22 December 2020

Response to Proposed Modification No. 6 to Oakdale West Estate – SSD - 7348 MOD - 6 at No. 2 Aldington Road, Kemps Creek

Site Boundary	
Building 17.15m Setback to Main Road	
Landscape 7.15m Setback to Main Road	
Building 7.5m Setback	
Landscape 3.75m Setback	
Chainwire Fencing	
Palisade Fencing	
Retaining Wall

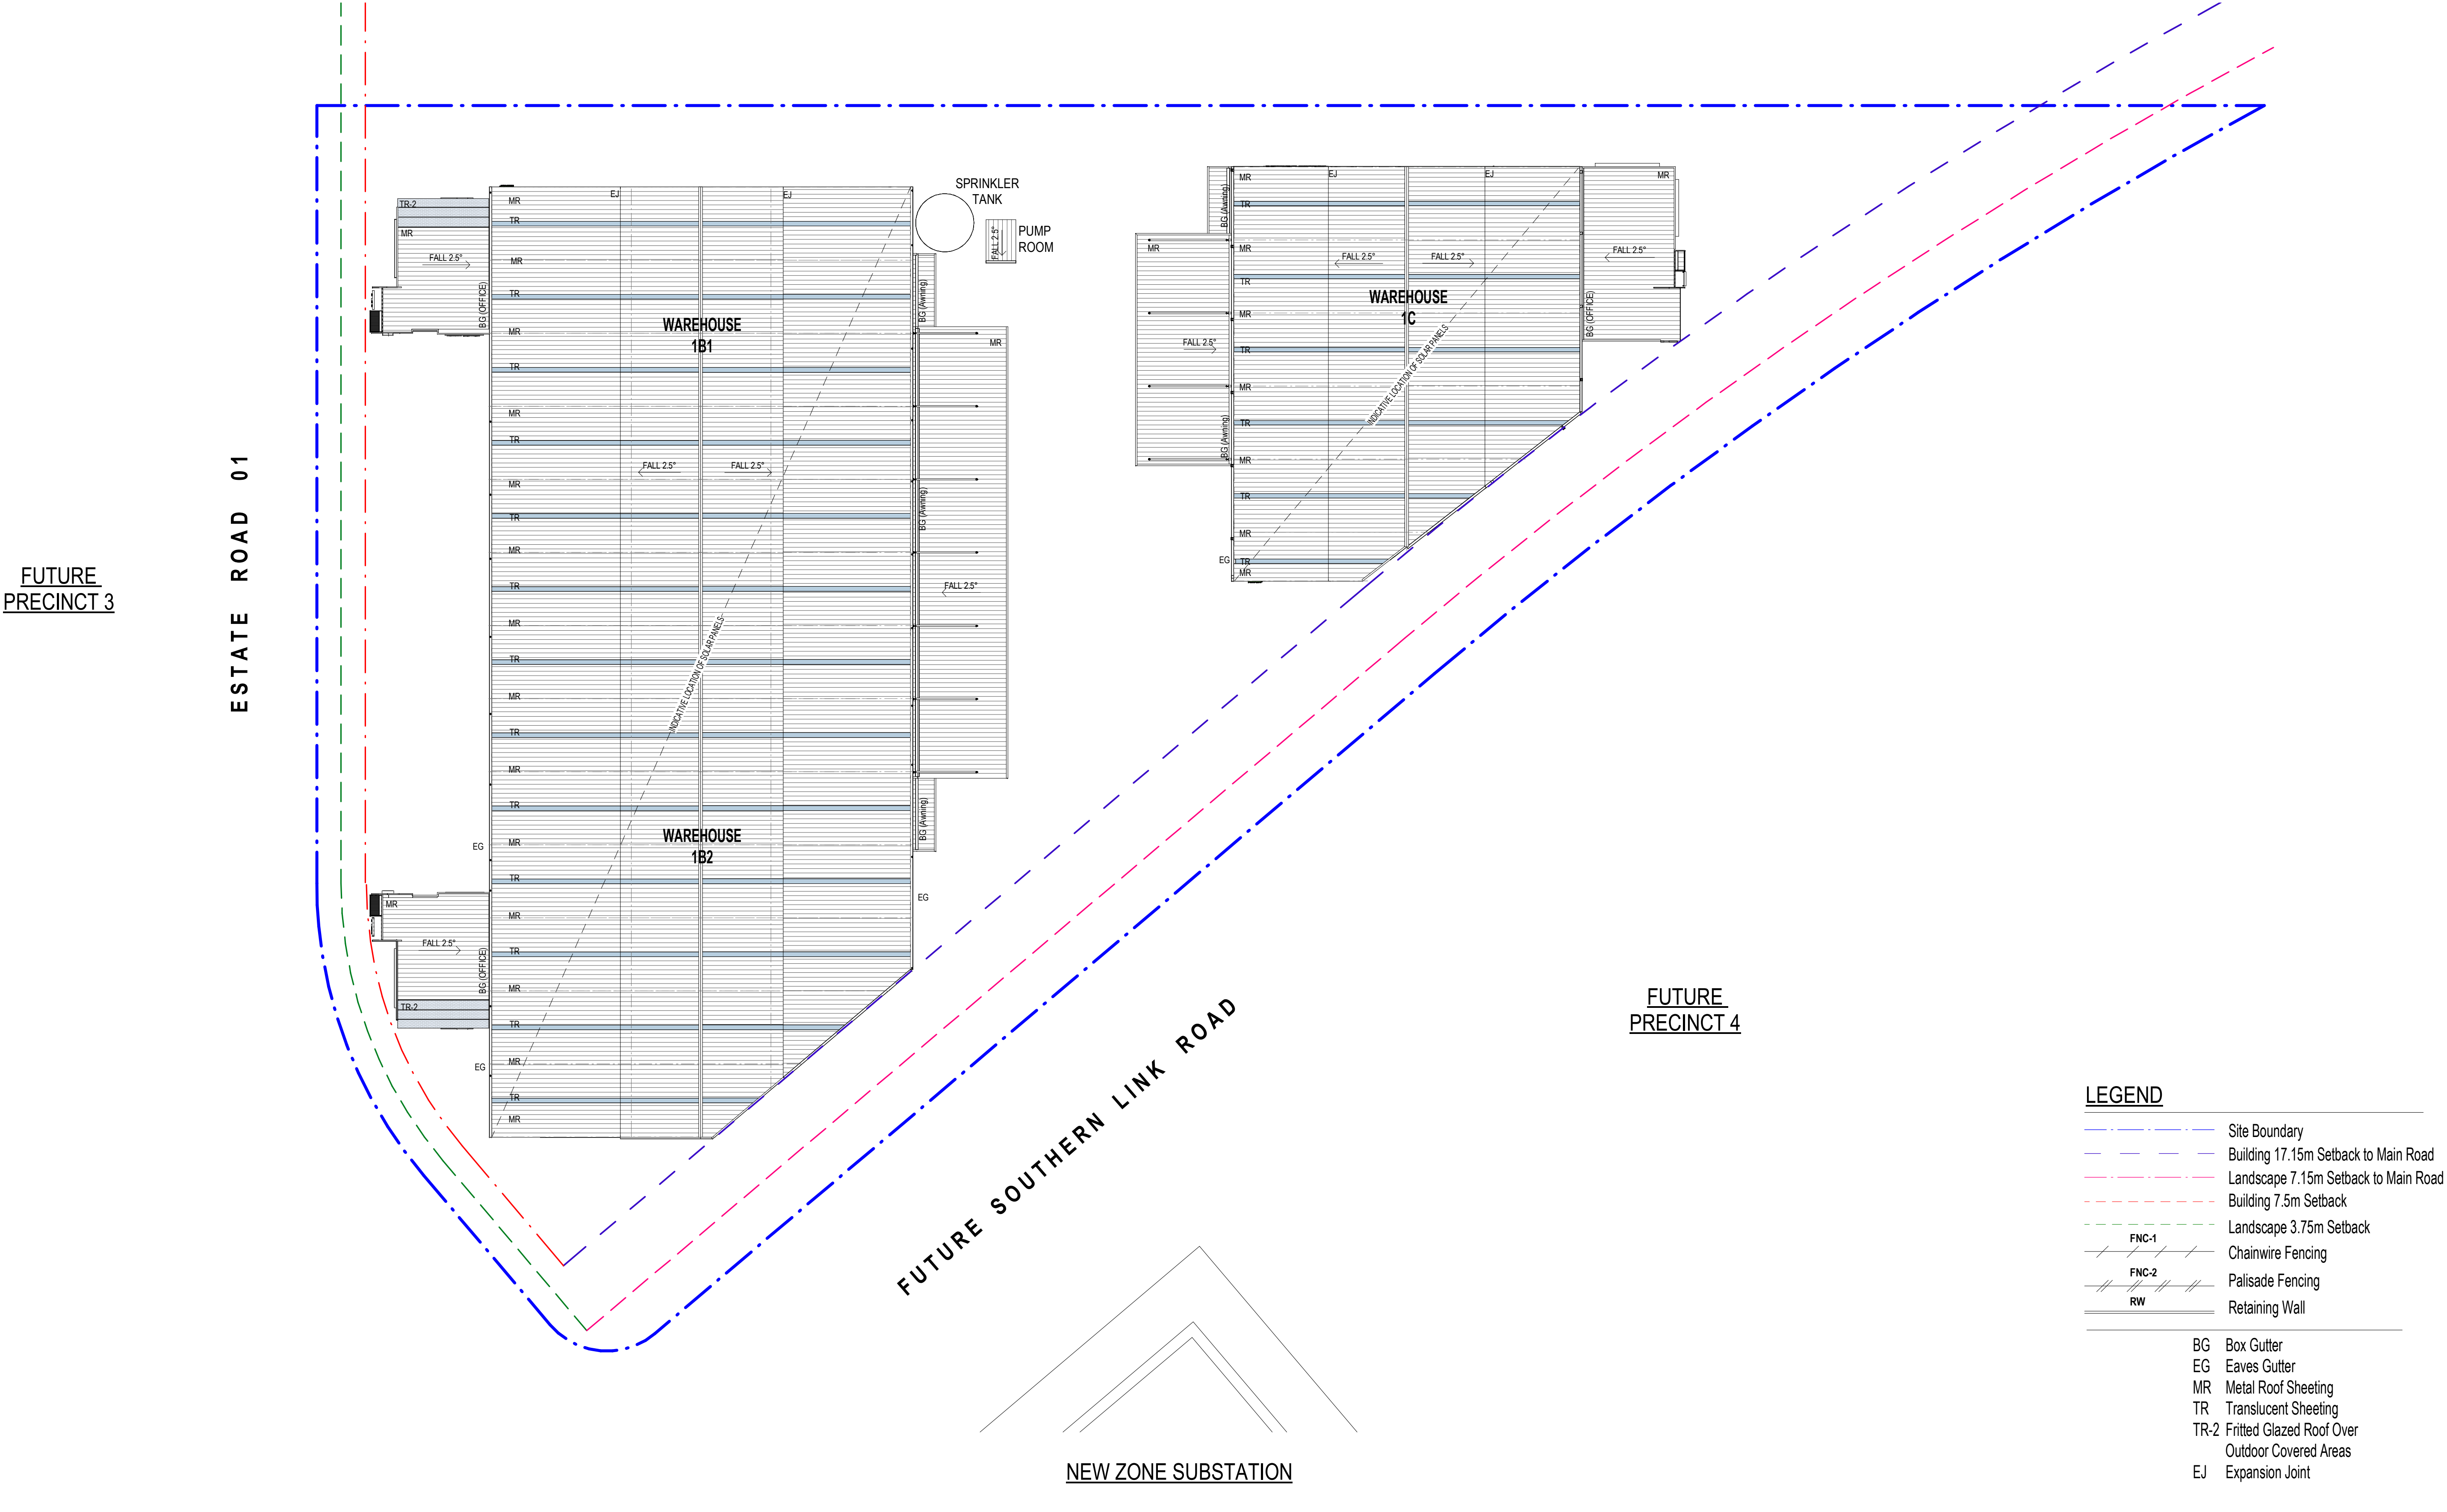
- Warehouse 1B1: While the setback from the front property boundary (Estate Road 1) to the car parking is 7.5m as approved previously, there is an indication of hard stand paving which erodes the landscaping design required for this setback zone. While a footpath from the kerb line to the office entry may be reasonable (if a footpath is being constructed in the road reserve), the extension of this paved area in front of parking spaces should be deleted and the landscaping reinstated in this location. The suggestion of a pram ramp from the shared zone to the paved area should be removed and redesigned so that access is from the end of the aisle extension of the car park, to the office entry and not out into the front setback zone which should be planted out as a continuous 7.5m landscaped zone.

- Warehouse 1B1 – The indication of bike parking on the above paved area is also unsupportable and should be removed and relocated within the site and not in a location that erodes necessary setback planting between the car park and property boundary.

- Warehouse 1B2: Same issues as above with Warehouse 1B1 with respect to paving in required landscape setback zone and relocation of indicated bike parking.
